**RE: Chaparral Elementary School Portable Relocation
Traffic Circulation Layout
Engineer's Stamp Dated 4-14-15 (File: F10-D005)**

Based upon the information provided in your submittal received 3-27-15, the above referenced plan cannot be approved for Building Permit until the following comments are addressed:

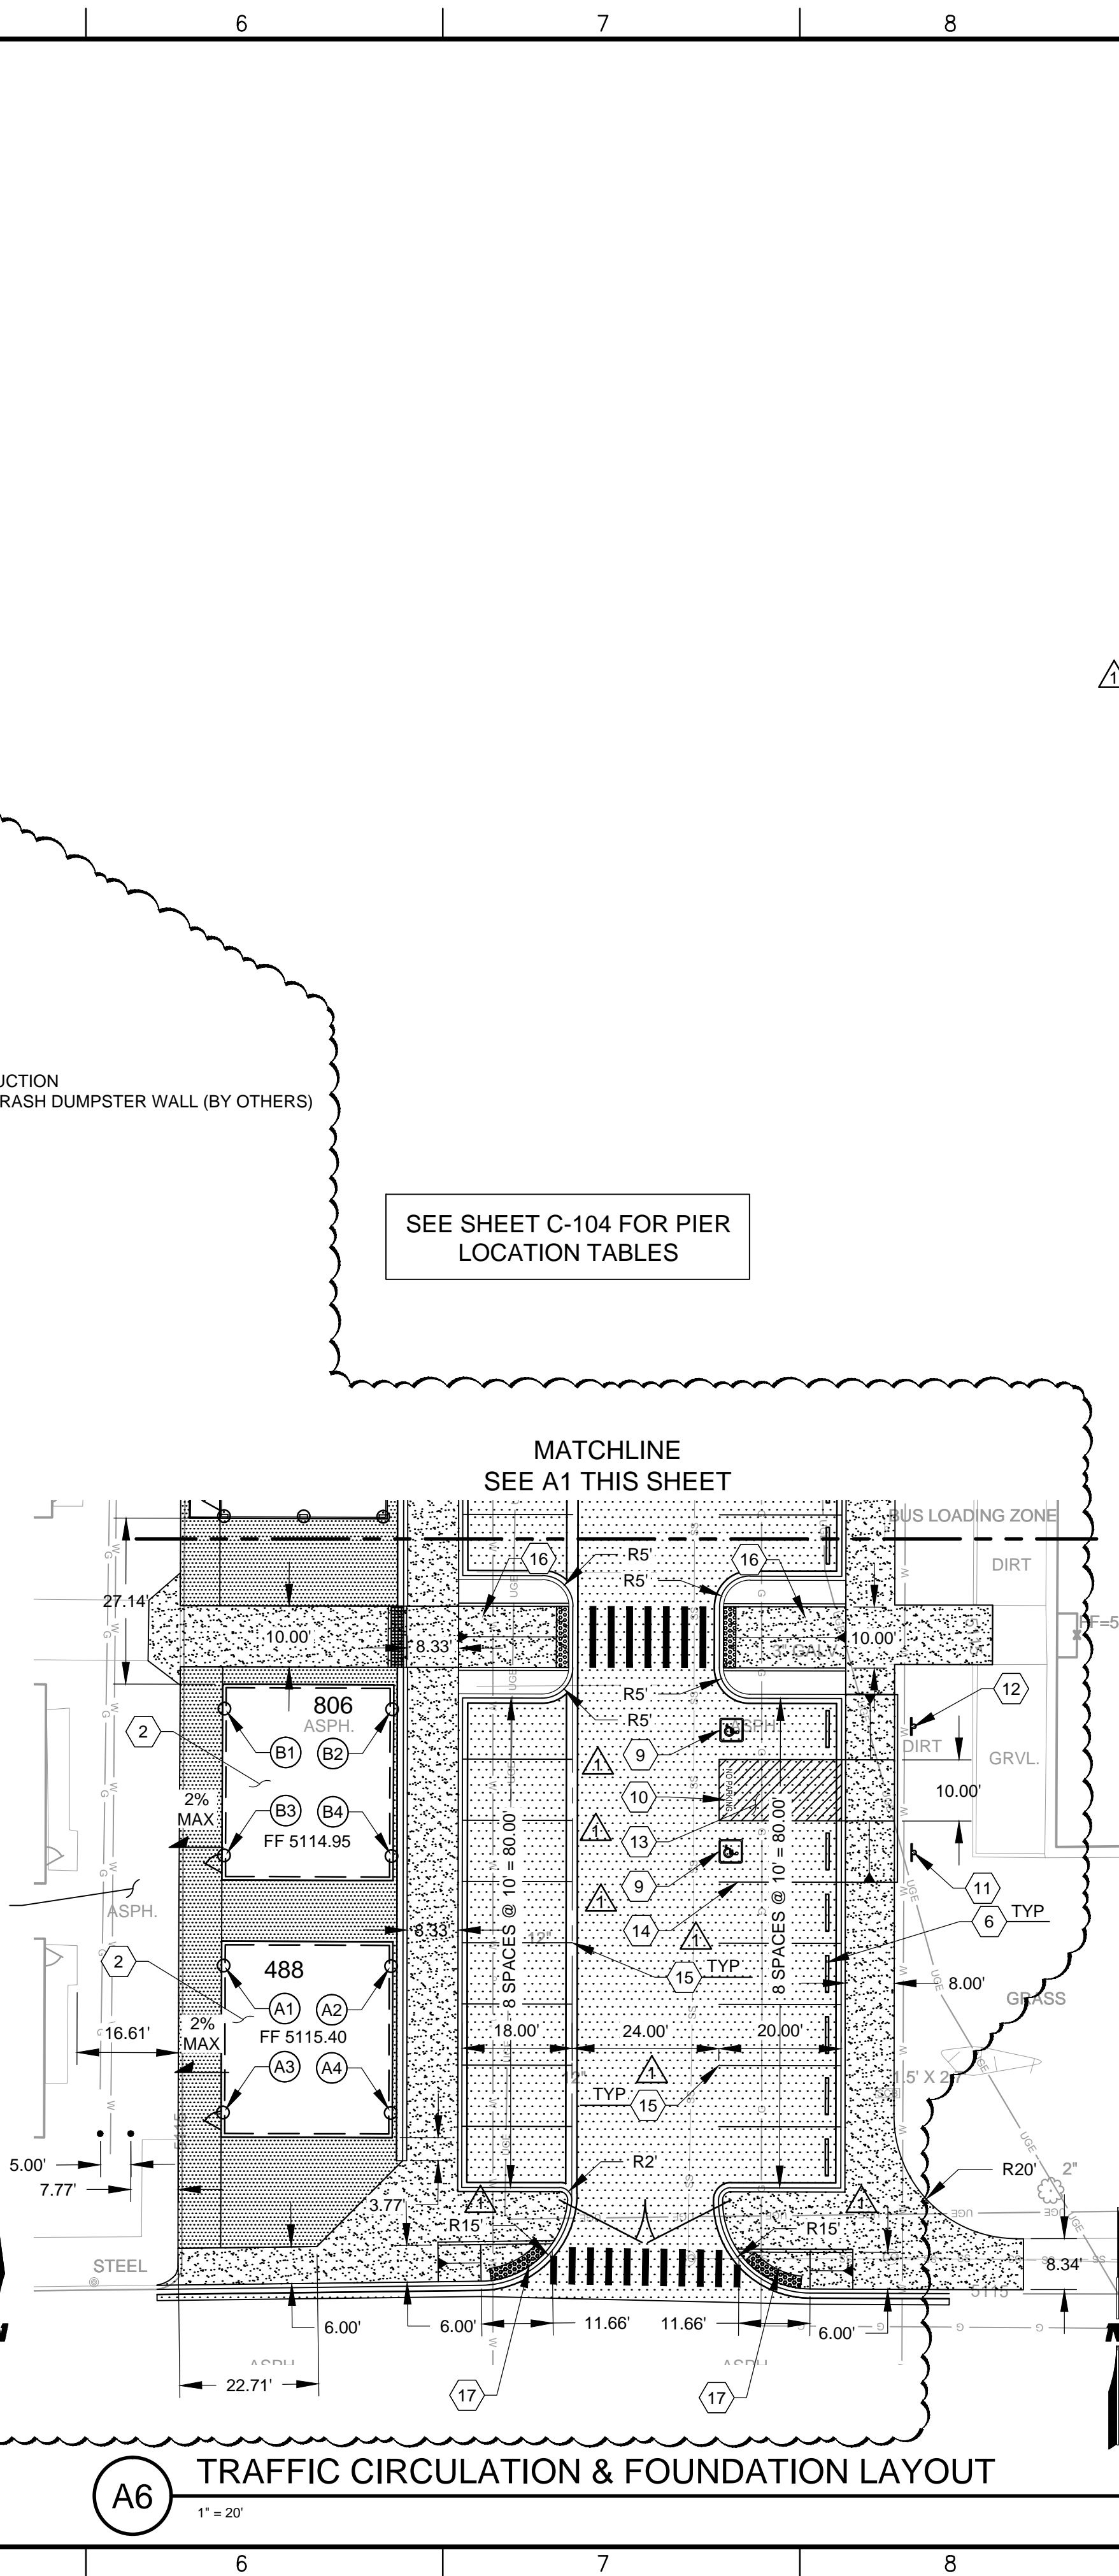
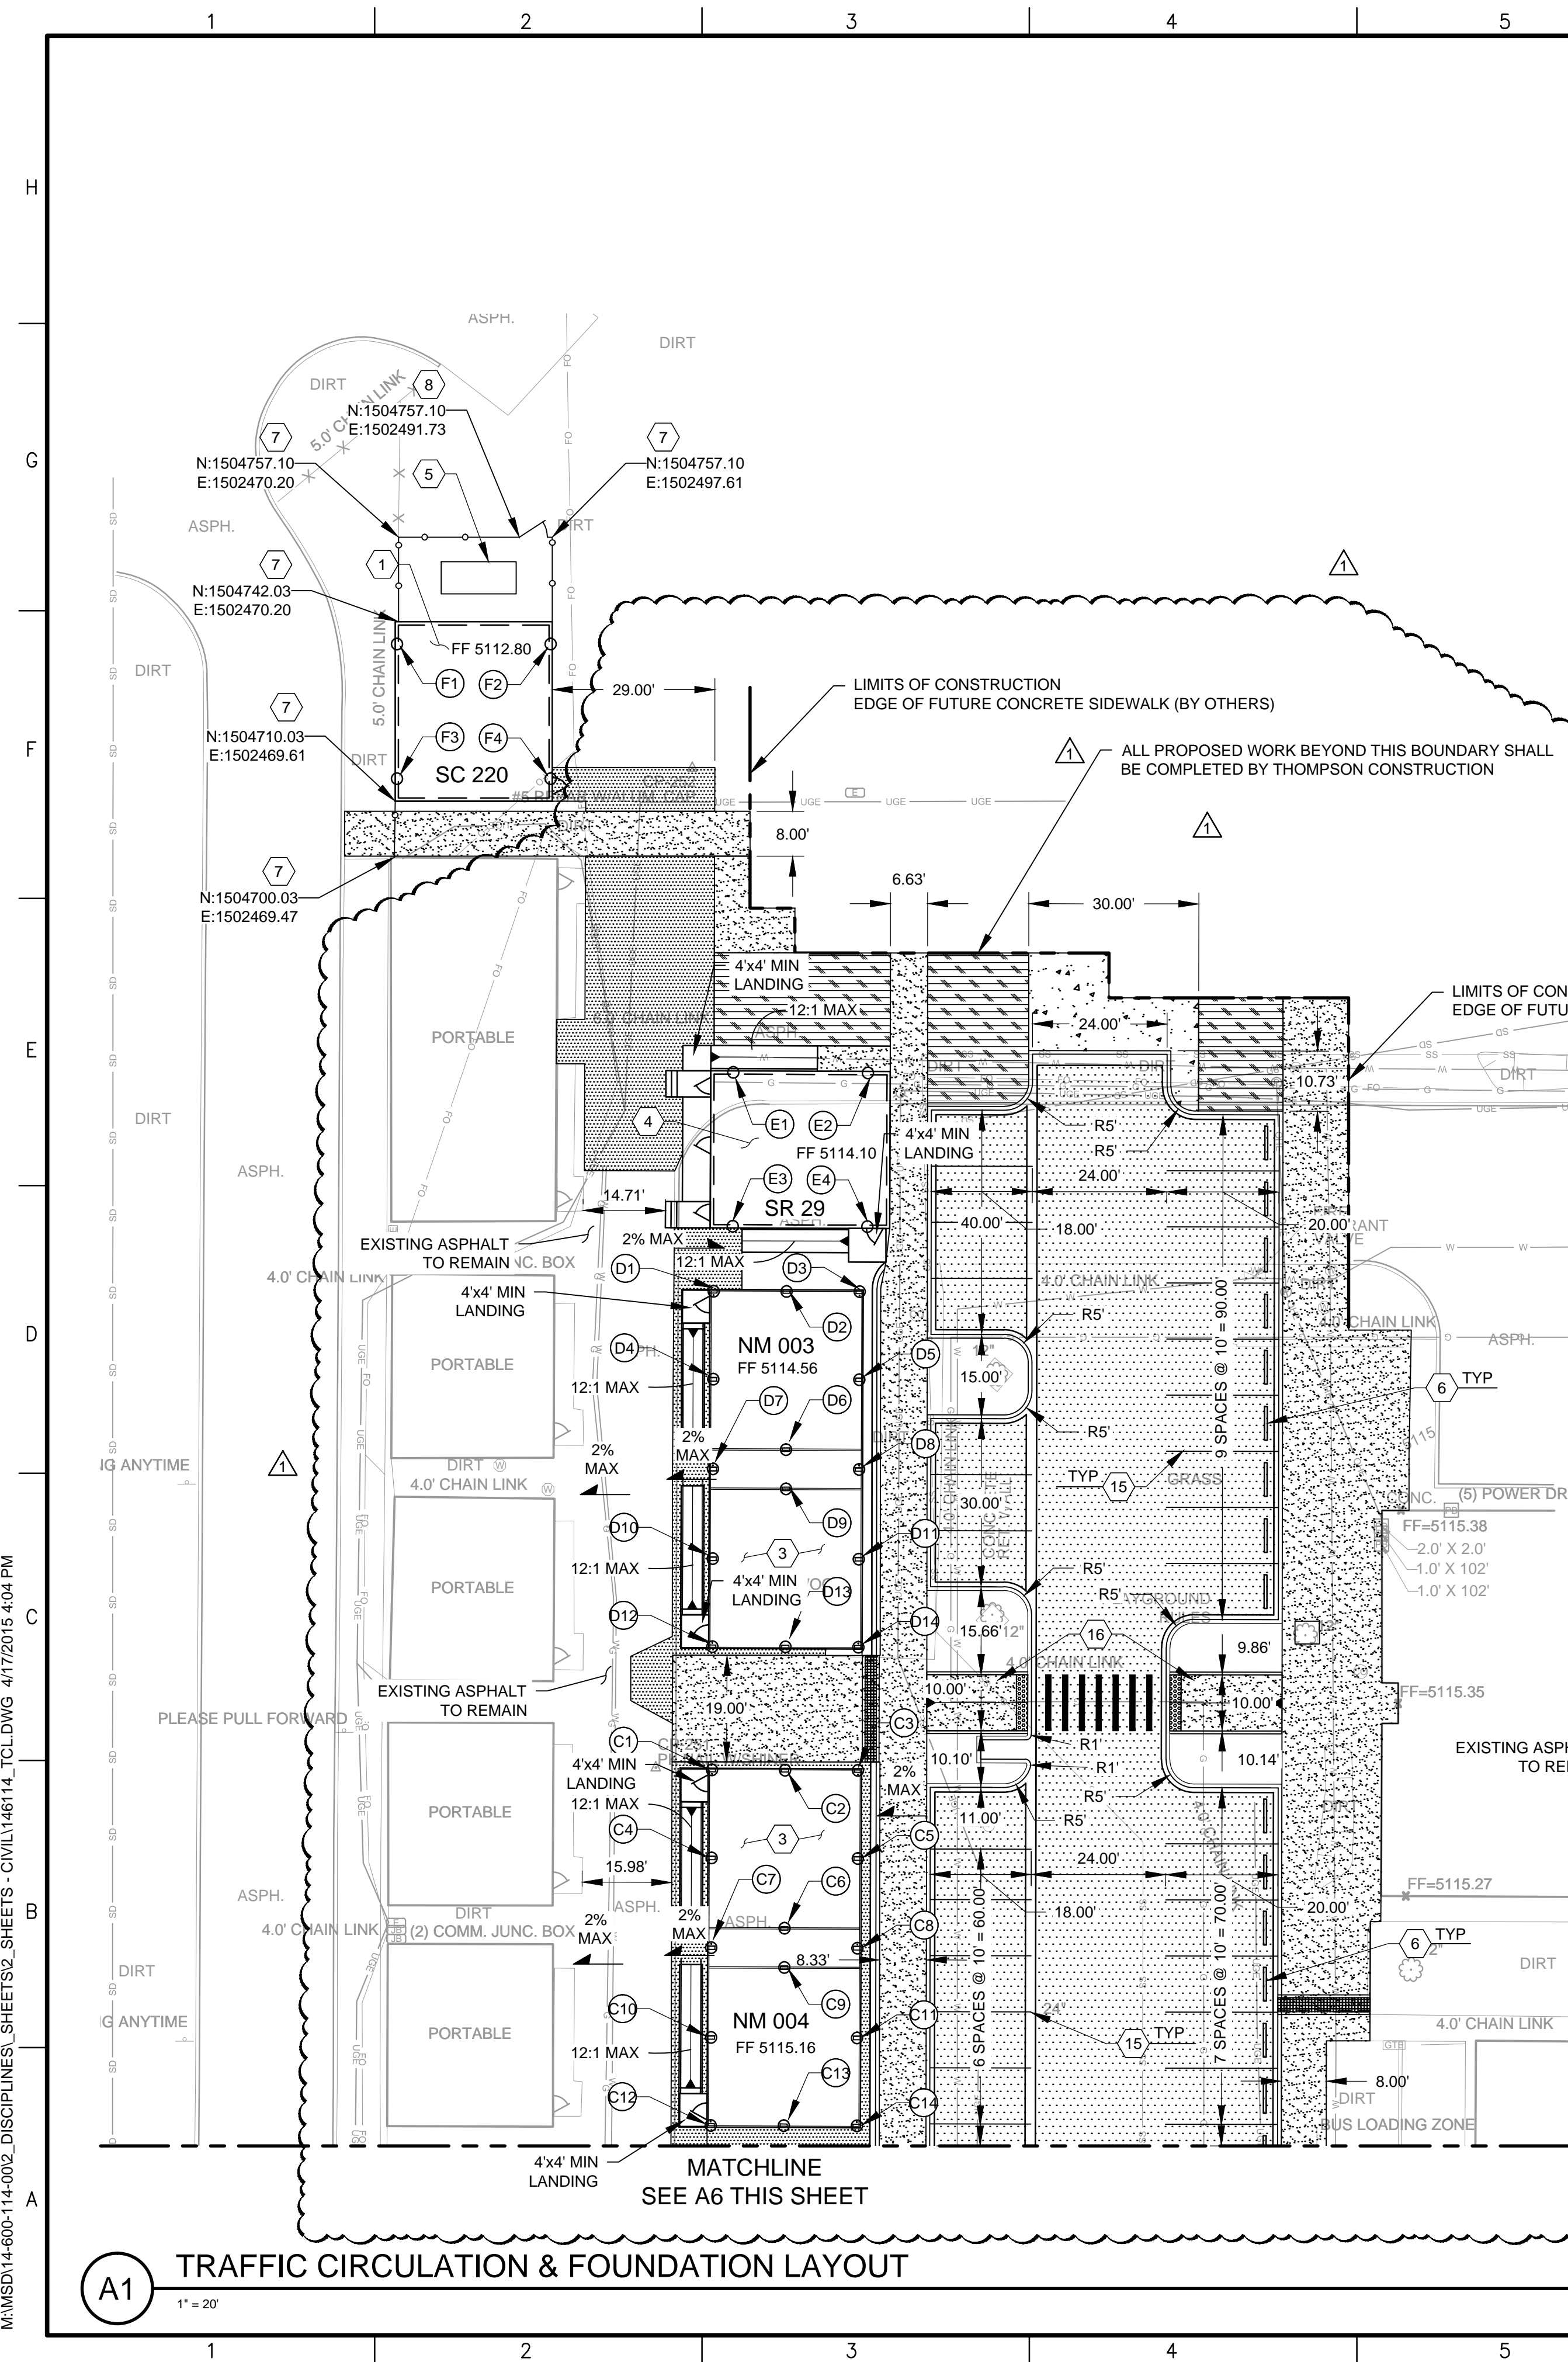
- 1) Show curb radii at entrance into new parking lot. The radii should be a minimum of 15 feet for passenger vehicles. Label beginning and end of this new curb.

- 2) Call out width of keyway at far northern end of the parking lot.
- 3) Show all existing doorways for portables, call out 12:1 maximum slope for all ramps leading into the portable buildings, and indicate a minimum 4-foot by 4-foot landing for wheelchair turning purposes at the top of the ramps.

- 4) To demonstrate ADA accessibility from parking lot curb ramp to the portable buildings, call out a maximum 2% cross-slope on the walkways from the curb ramp to each of the ramps at the portables. If the existing asphalt to the west of the new buildings is to remain and be used as part of the ADA accessible pathway to these new buildings, call for existing asphalt to remain.

- 5) On the Traffic Circulation Layout Sheet, please reference sheet numbers for curb ramp details and handicapped parking signage. Include necessary keyed notes.

- 6) For the ADA van access aisle, the words "NO PARKING" shall be at least one foot high and at least two inches wide (66-1-4.1.B NMSA 1978). Call out these dimensions for this wording somewhere on the plan.
